1st June 2021

Arundel Town Council
Maltravers Street
Arundel
BN18 9AP

Application No: AB/55/21/L
Site Address: 61 High Street Arundel BN18 9AJ
Description of works: Listed building consent for the removal of the built-in seating, removal of the internal false timber cladding, lowering of height of food service hatch, installation of fold-down access ramp to basement steps, overlay of WC floor materials with single-ply membrane & 1 No. illuminated halo advertisement on front elevation.

DRAWING TITLE  
PROPOSED BASEMENT PLAN, FIRST  
FLOOR PLAN AND FRONT ELEVATION

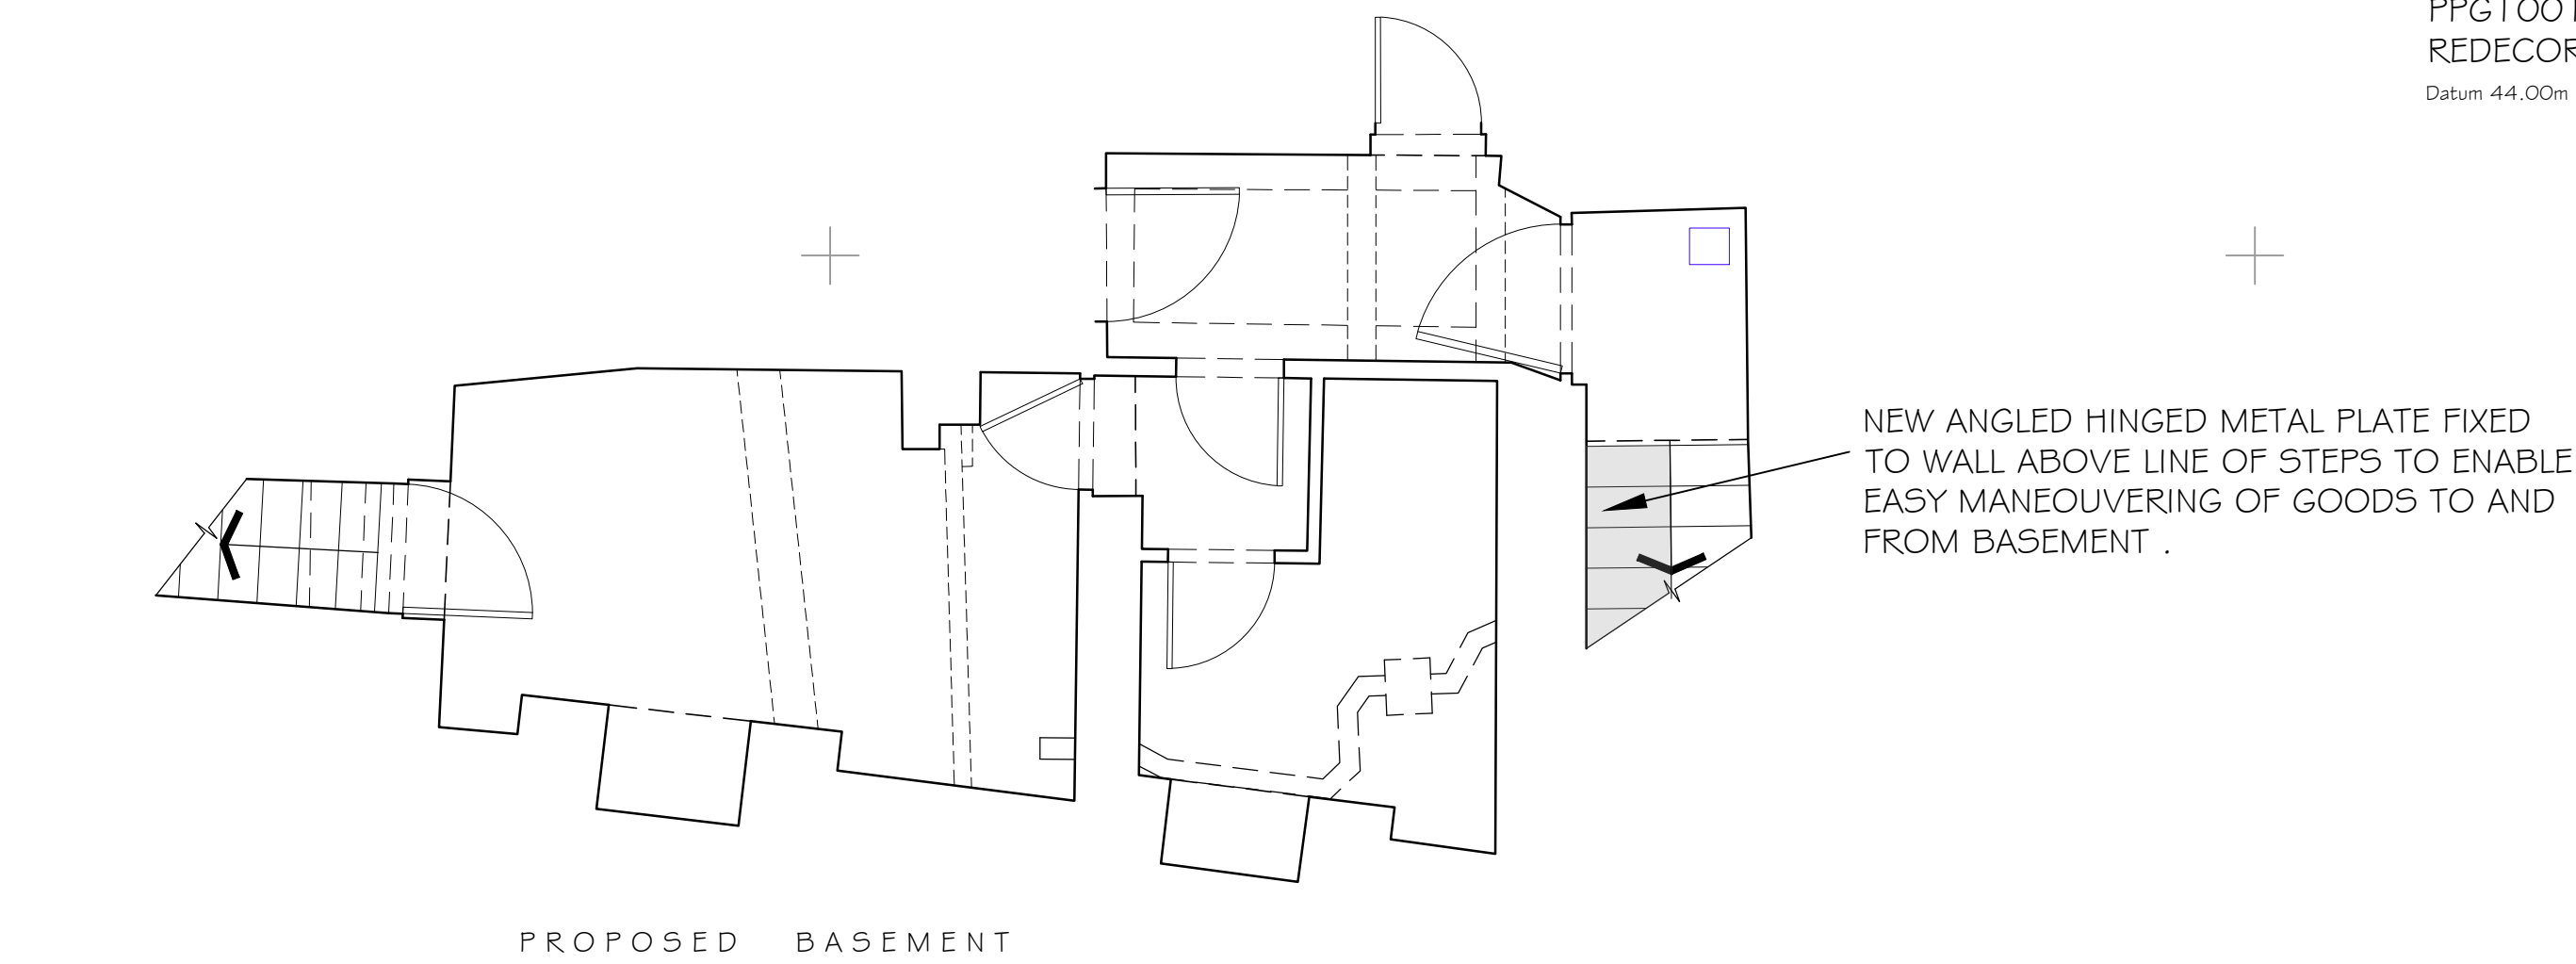
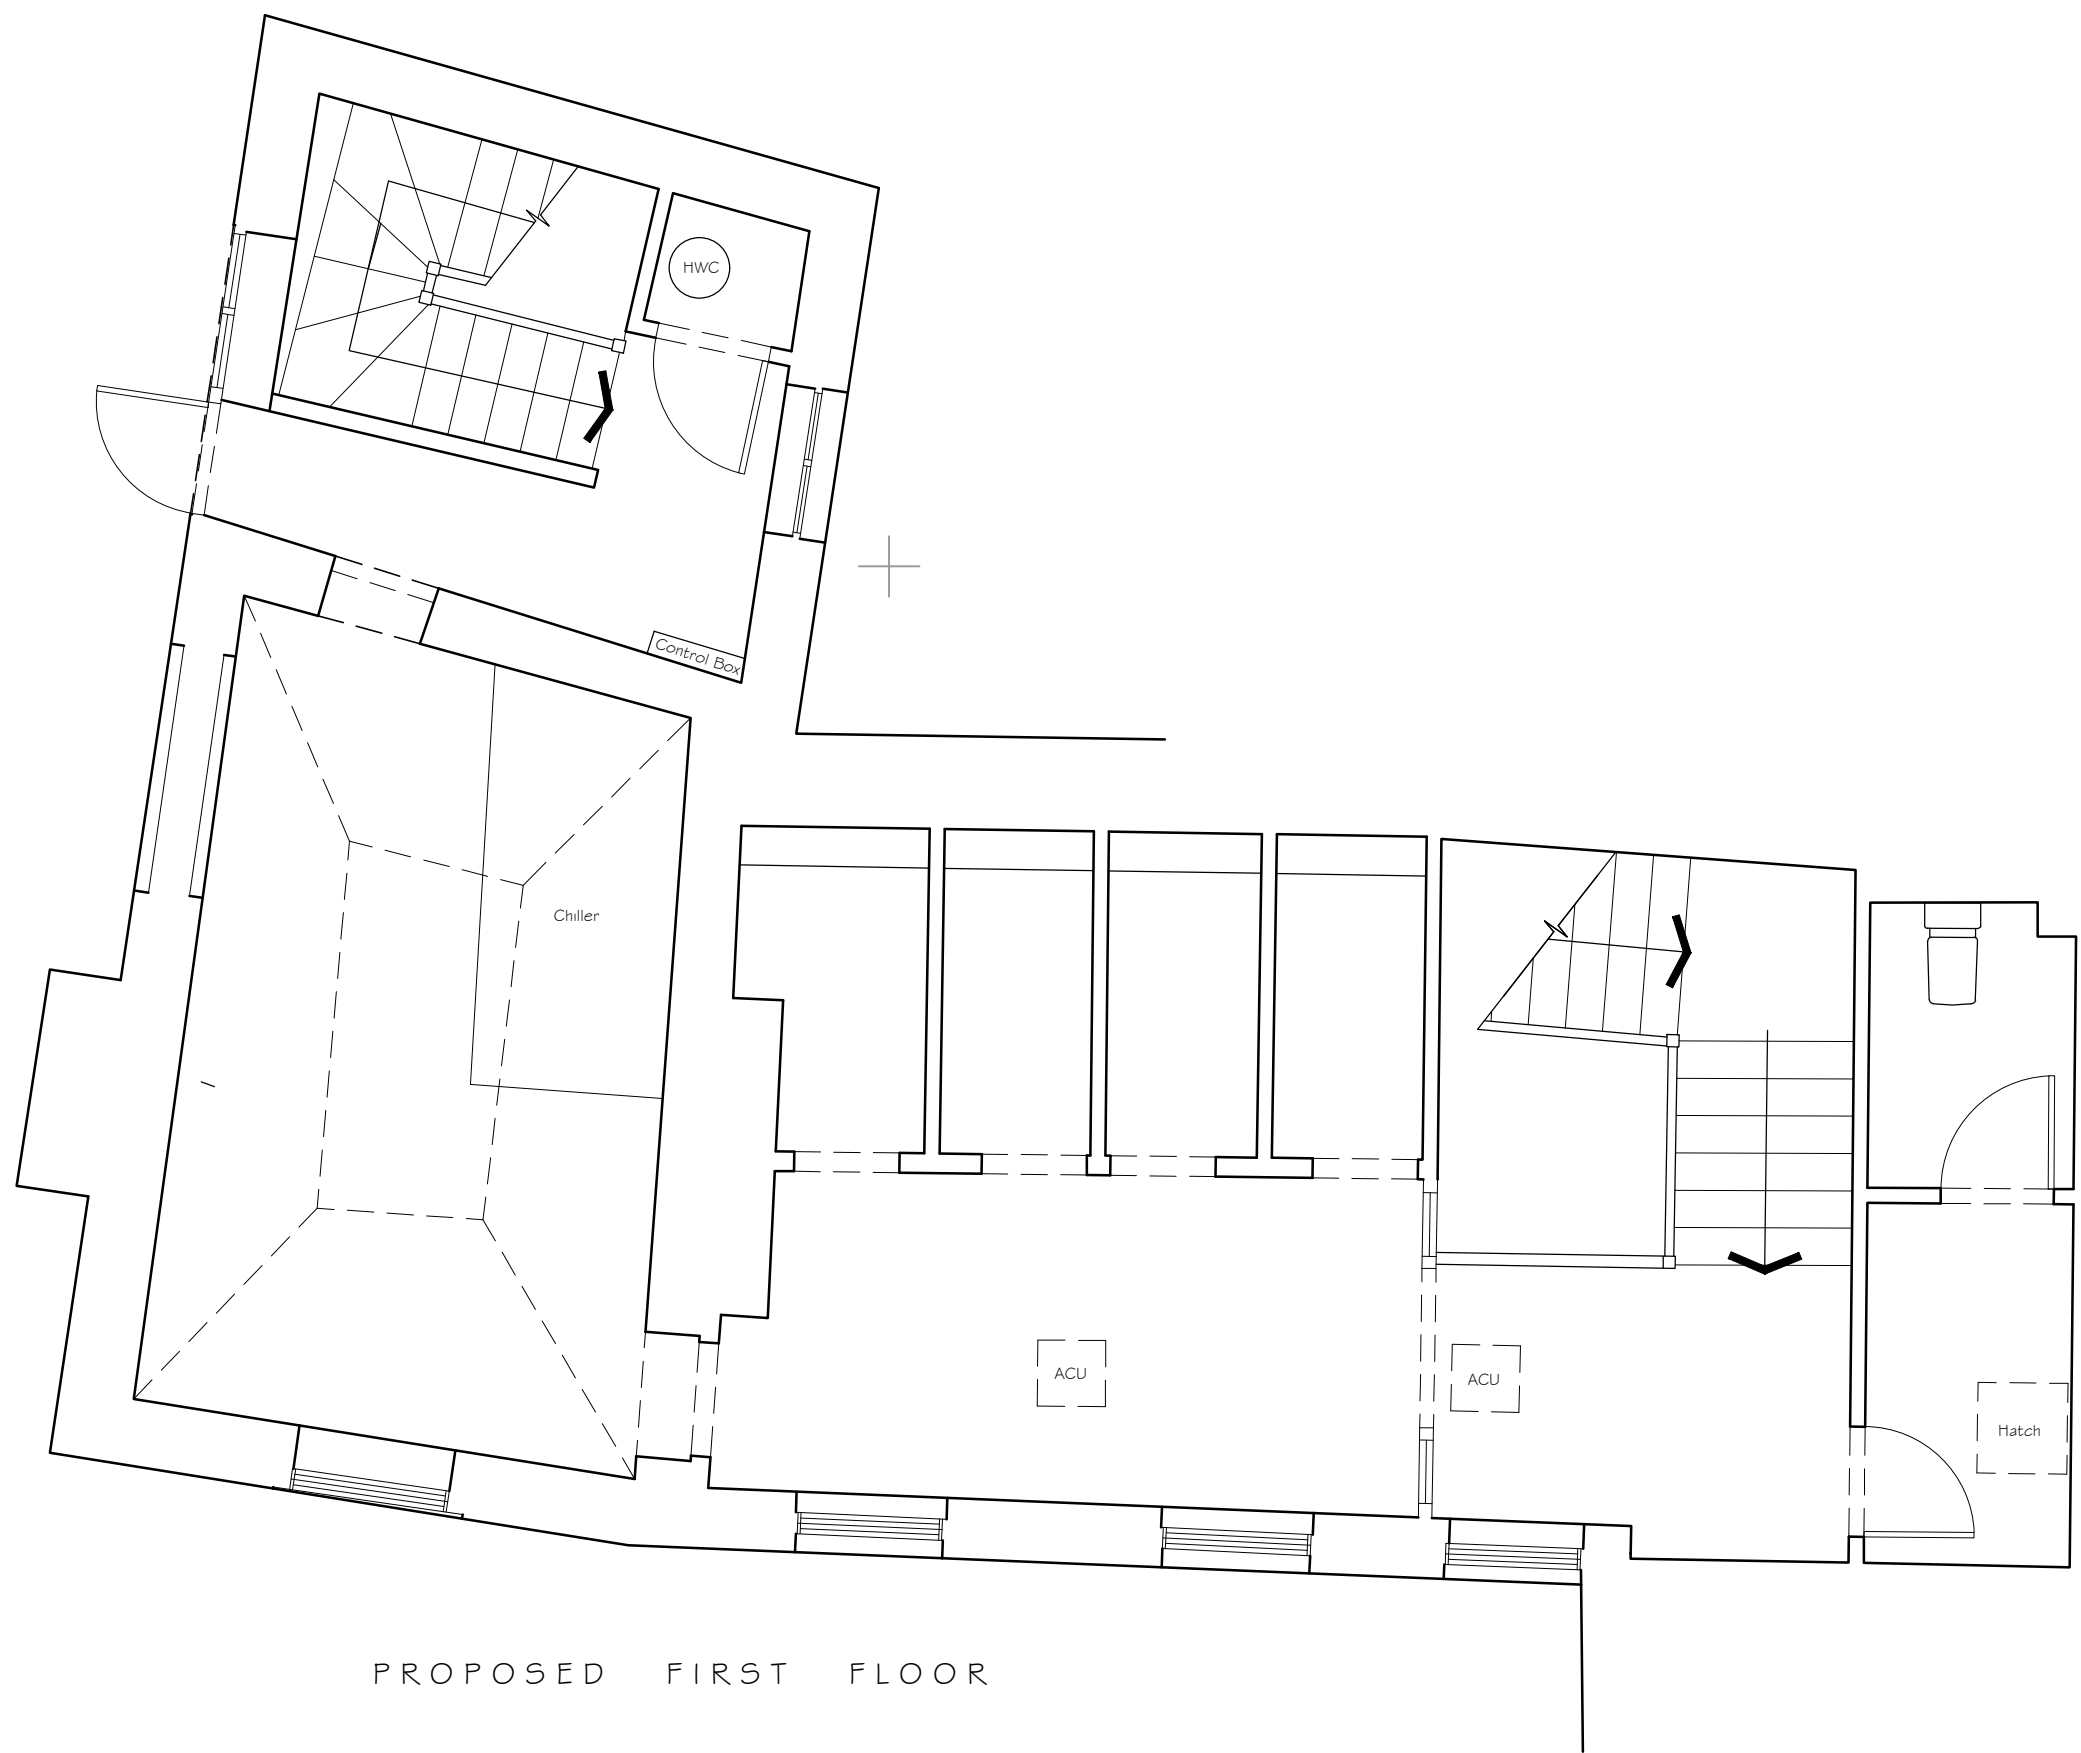
The Committee objected to the Application on the grounds that the illuminated sign is halo lit. The new wall mounted lighting should be in keeping with the character of the building.
